From: Critchley Architecture and Design [REDACTED]
Sent: 20 December 2019 09:22
To: Zac Denton
Subject: Re: EP/132/19/PL - Request

The amount of new floor area created is identical to the original approval, although the applicant has decided to change the room layout on the ground floor. The internal changes are not a planning matter and so are not listed below.

Externally this and financial considerations have resulted in some changes to the fenestration, as follows:

PROPOSED ELEVATIONS

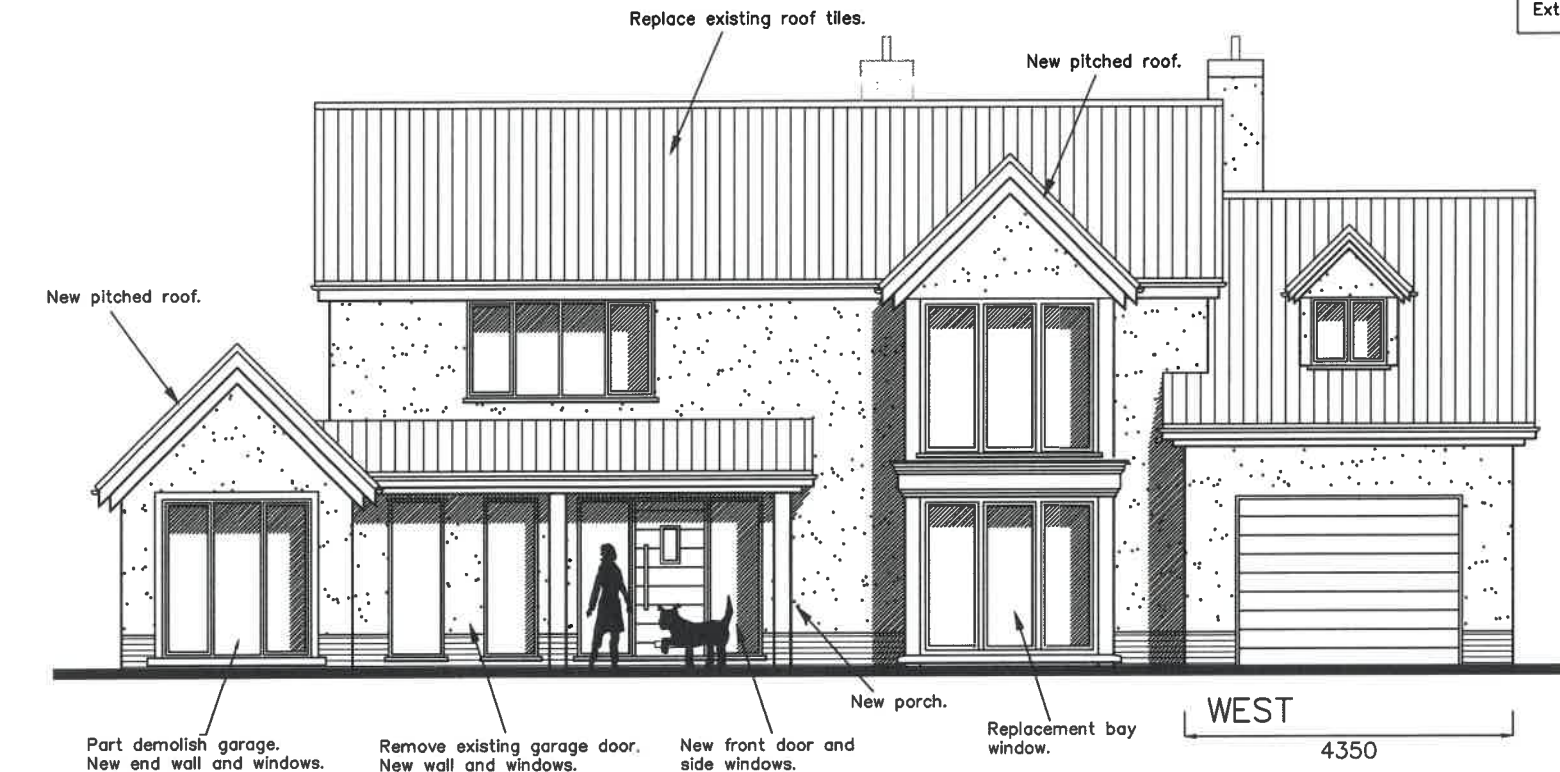
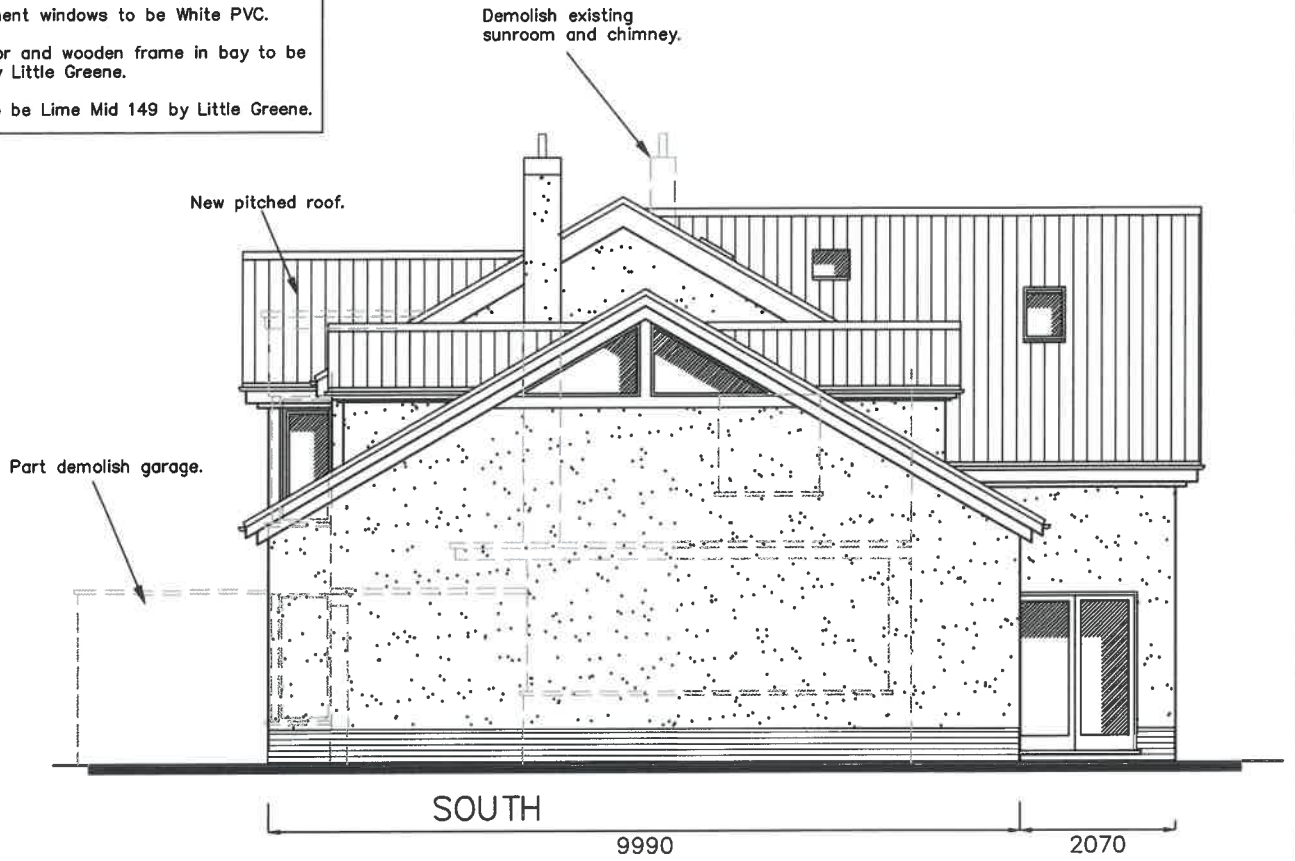
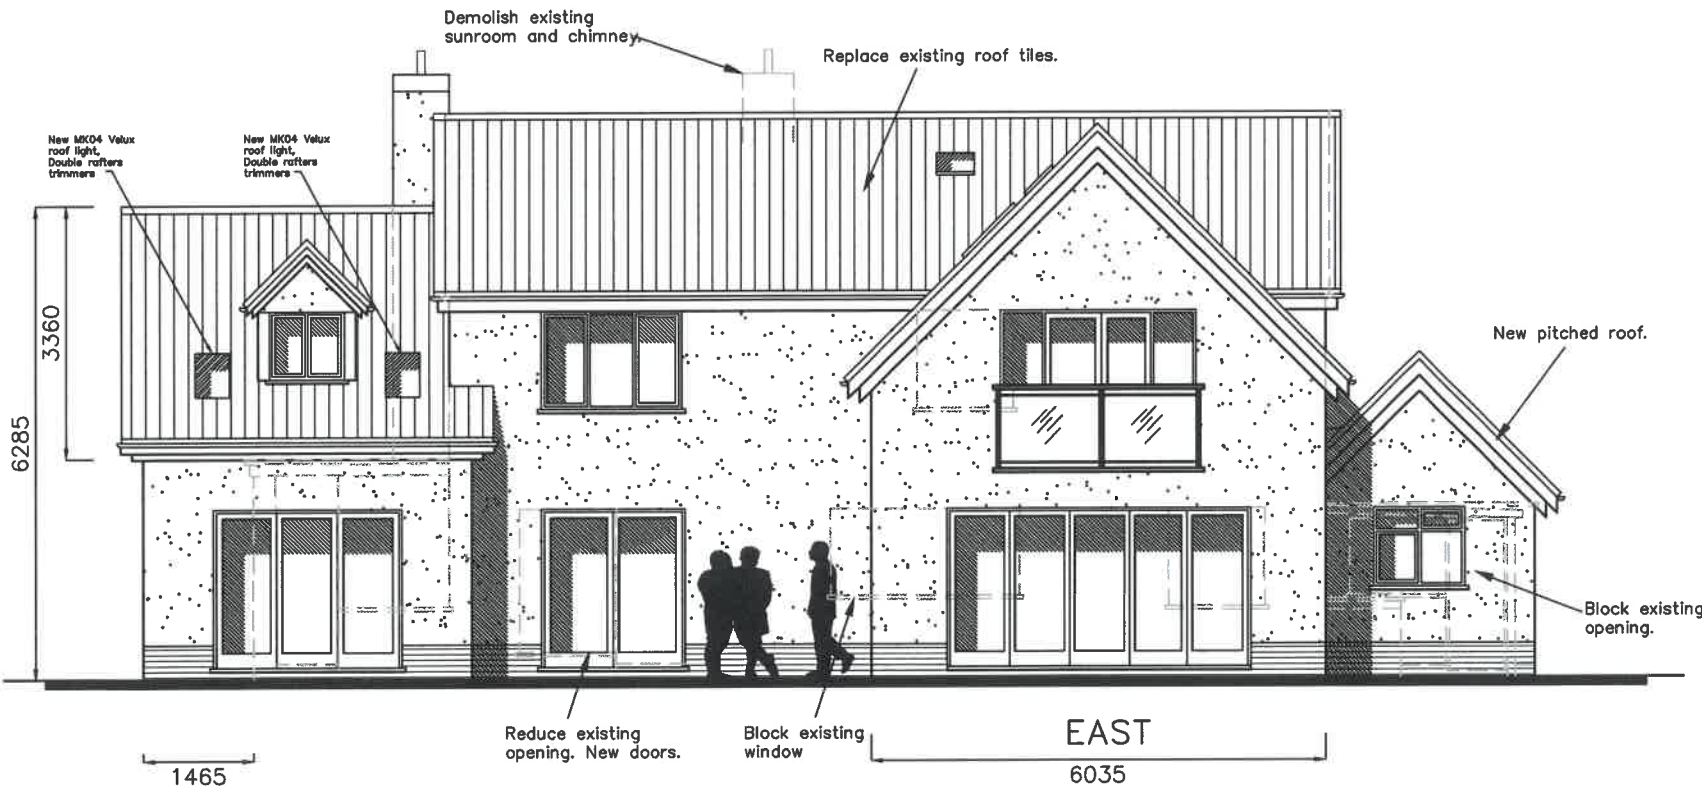
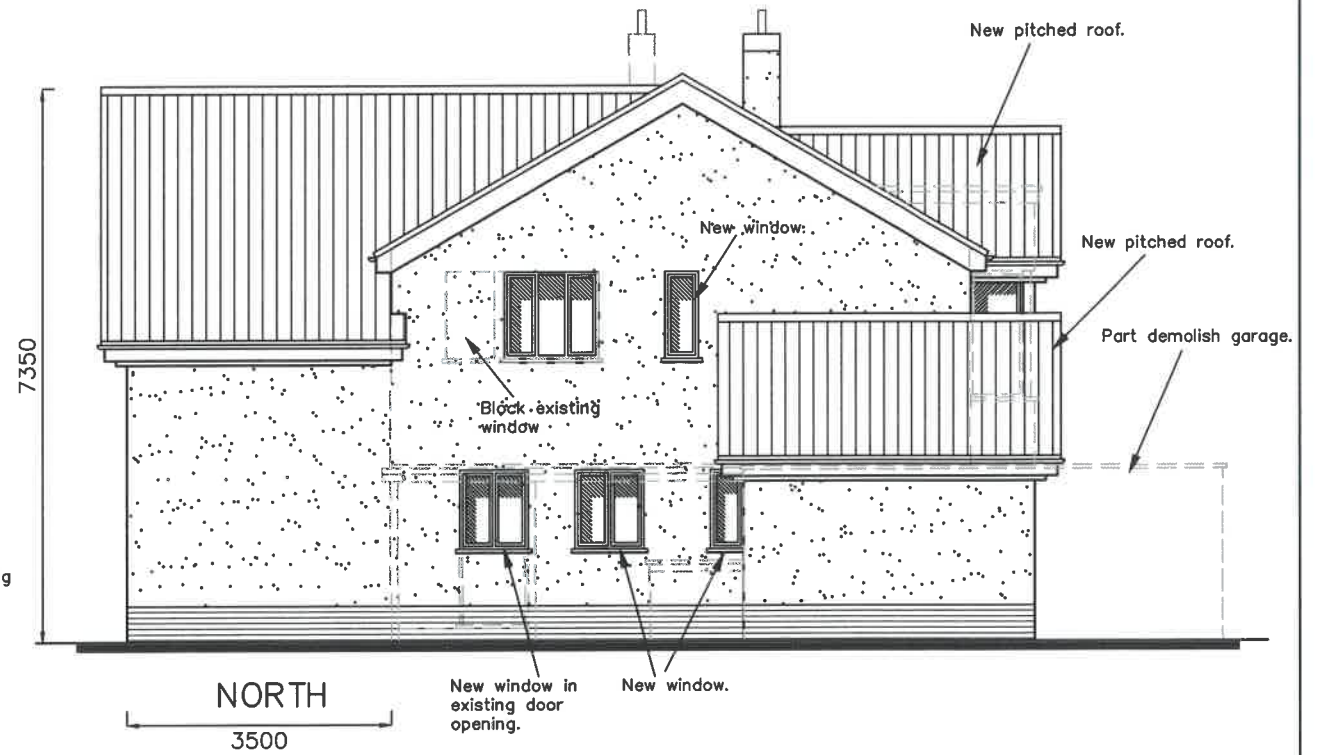
- Removal of glazed gables in West Elevation.
- Existing window sill in East Elevation not reduced.
- Sliding doors replace windows at rear of new extension (East Elevation)
- Juliet balcony replaces window at rear of Bed.3 (East Elevation).
- New window to rear of study.

Otherwise the external changes relate to the distribution of materials, which are as shown on drawing 18114-505B. The applicant has given us the exact colour of the render they wish to use (a warm neutral similar to the approved), which is listed on the drawing. The brickwork is as existing/approved and the proposed roofing has been upgraded from concrete to slate. An existing chimney is also retained.
